Recommendation Report for Planning Permission

REF NO: BR/257/19/PL

LOCATION: The Royal Hotel
The Esplanade
Bognor Regis
PO21 1SZ

PROPOSAL: Refurbishment, external alterations, extensions & reconfiguration of previously permitted conversion to rebuild ground floor A3 restaurant & provide a total of 27 flats. This application affects the character & appearance of The Steyne, Bognor Regis, Conservation Area (resubmission of BR/326/18/PL)

DRAWING NO.	REVISION
169 / 3.100	03

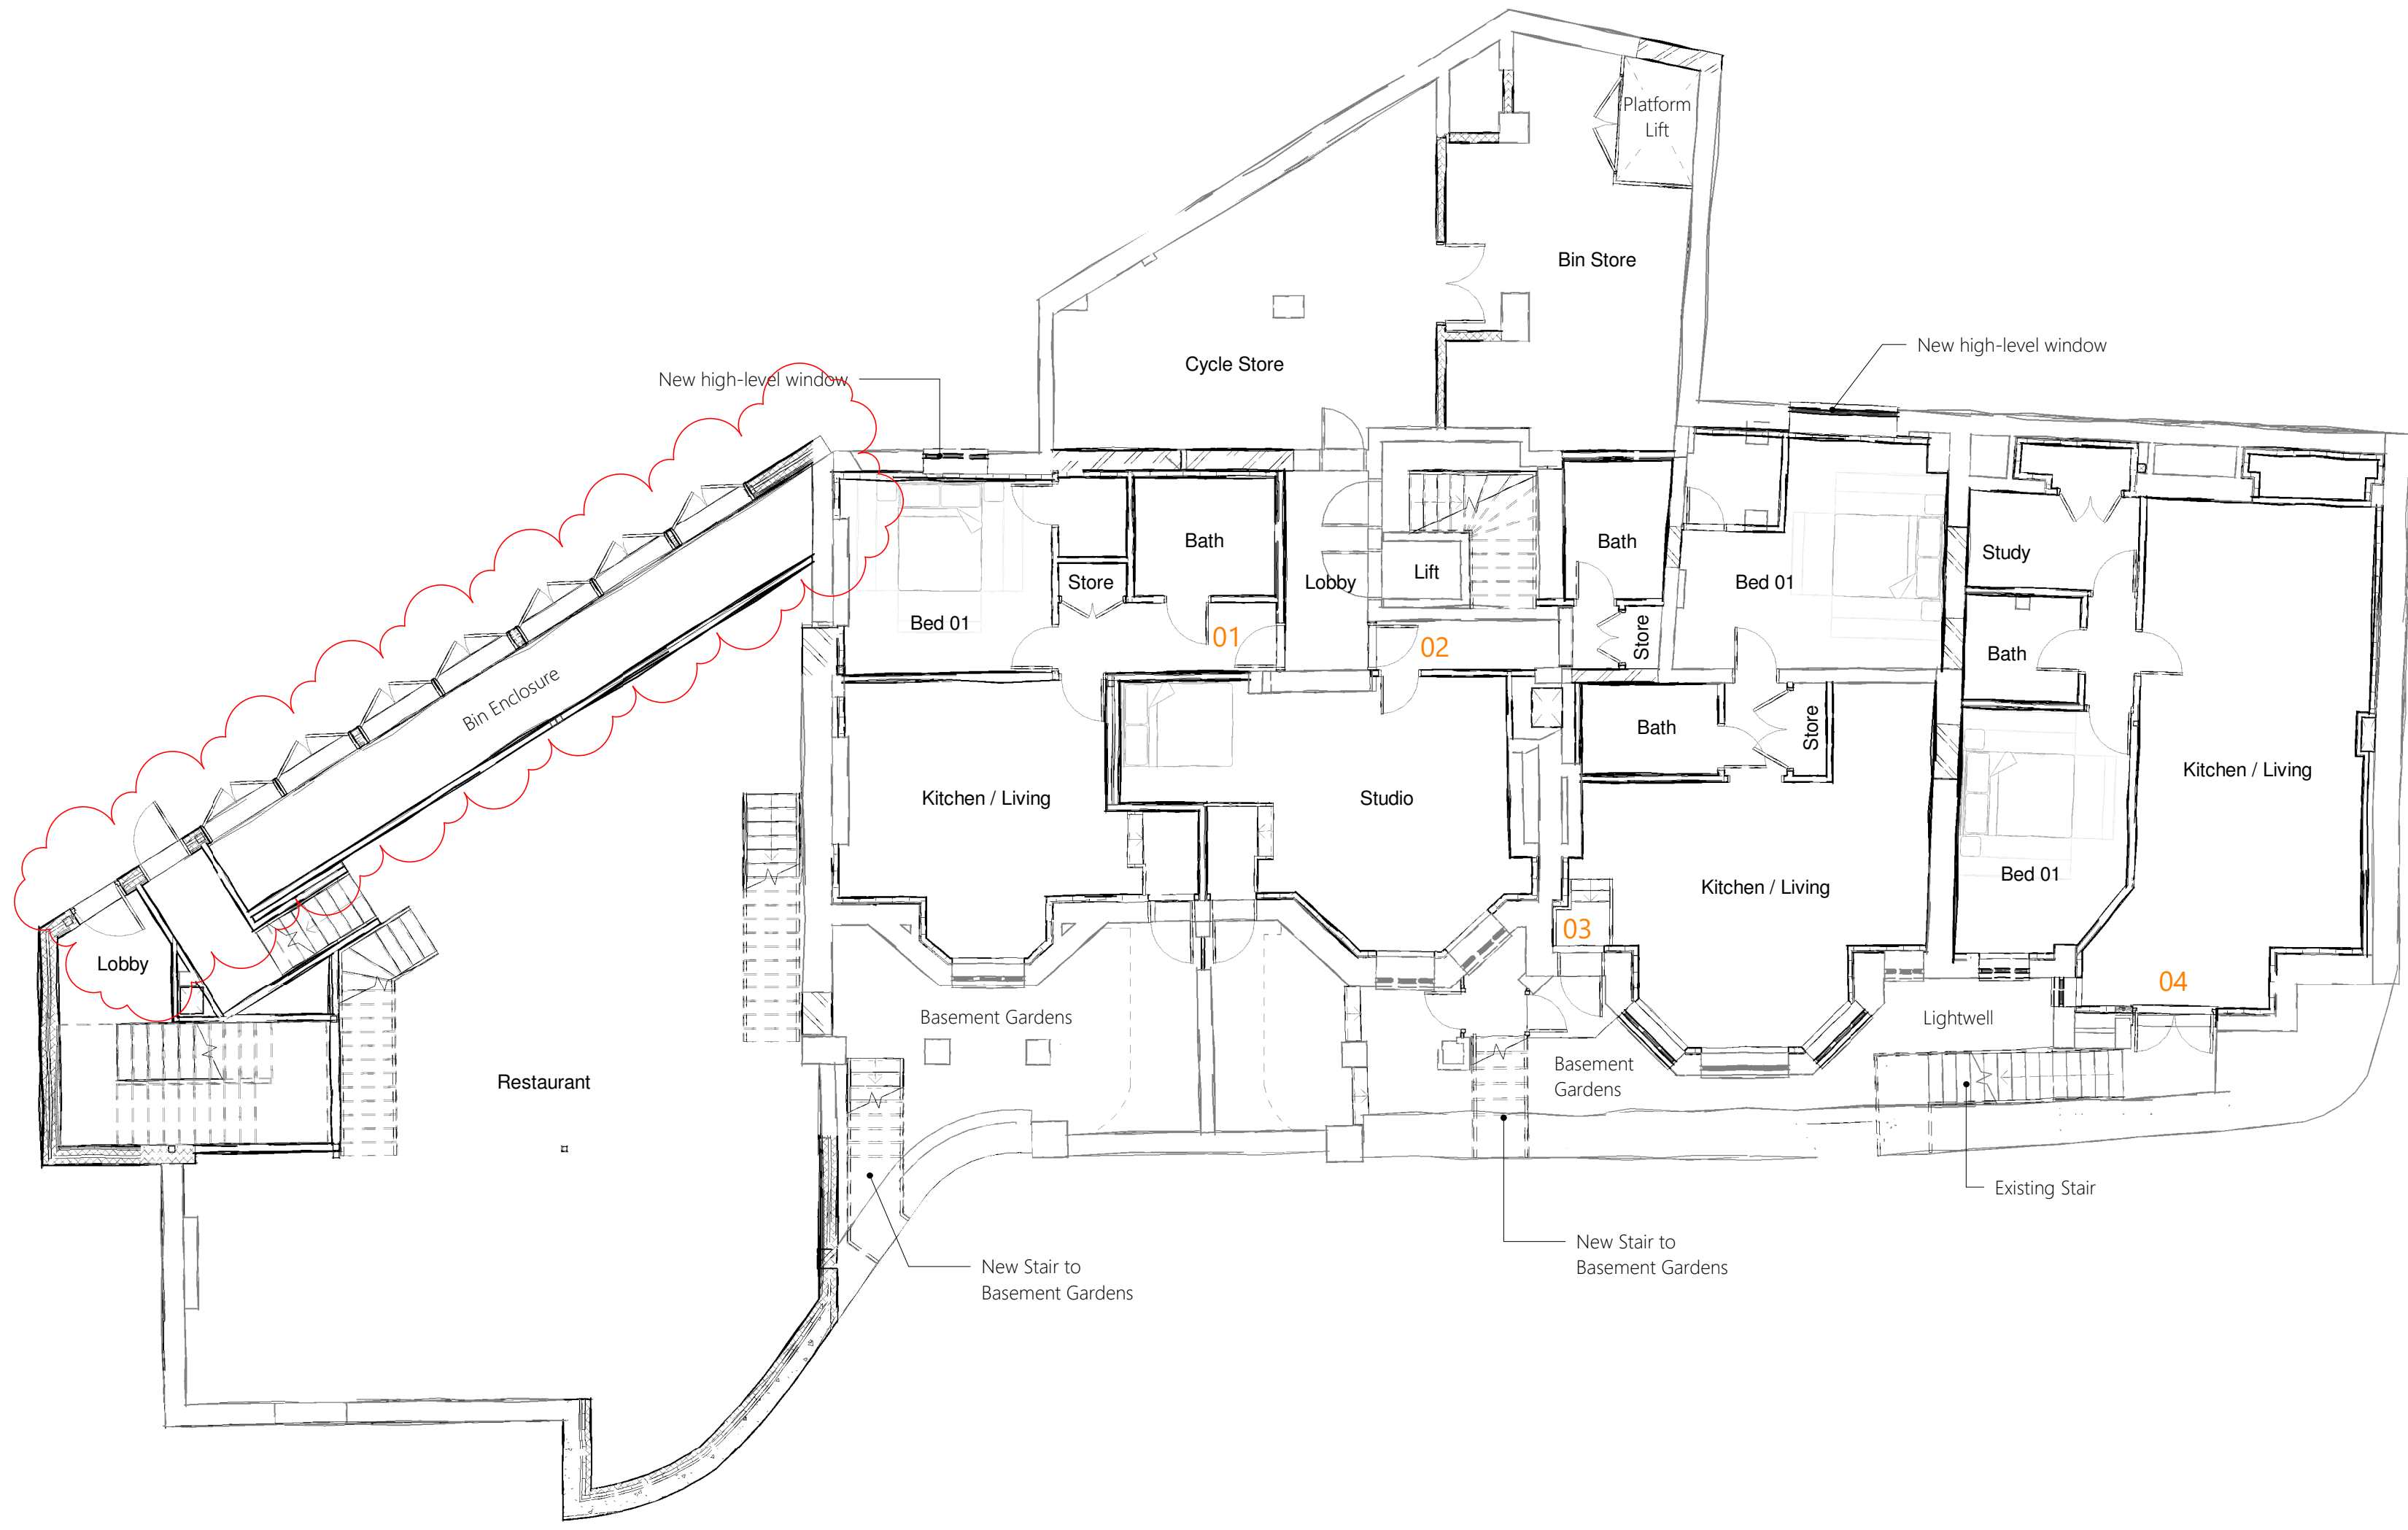
Lower Ground Floor:

Change to the internal arrangements of the Residential Bin & Cycle Store;
Two new high level (albeit appearing externally as ground level) windows on the North elevation;
Different arrangement for the internal stairs (note that this continues up through multiple floors);
Different arrangement for the restaurant floor area;
Different arrangement for the Restaurant bin enclosures;
Replacement of the existing nib walls with new walls in the western part of the building;
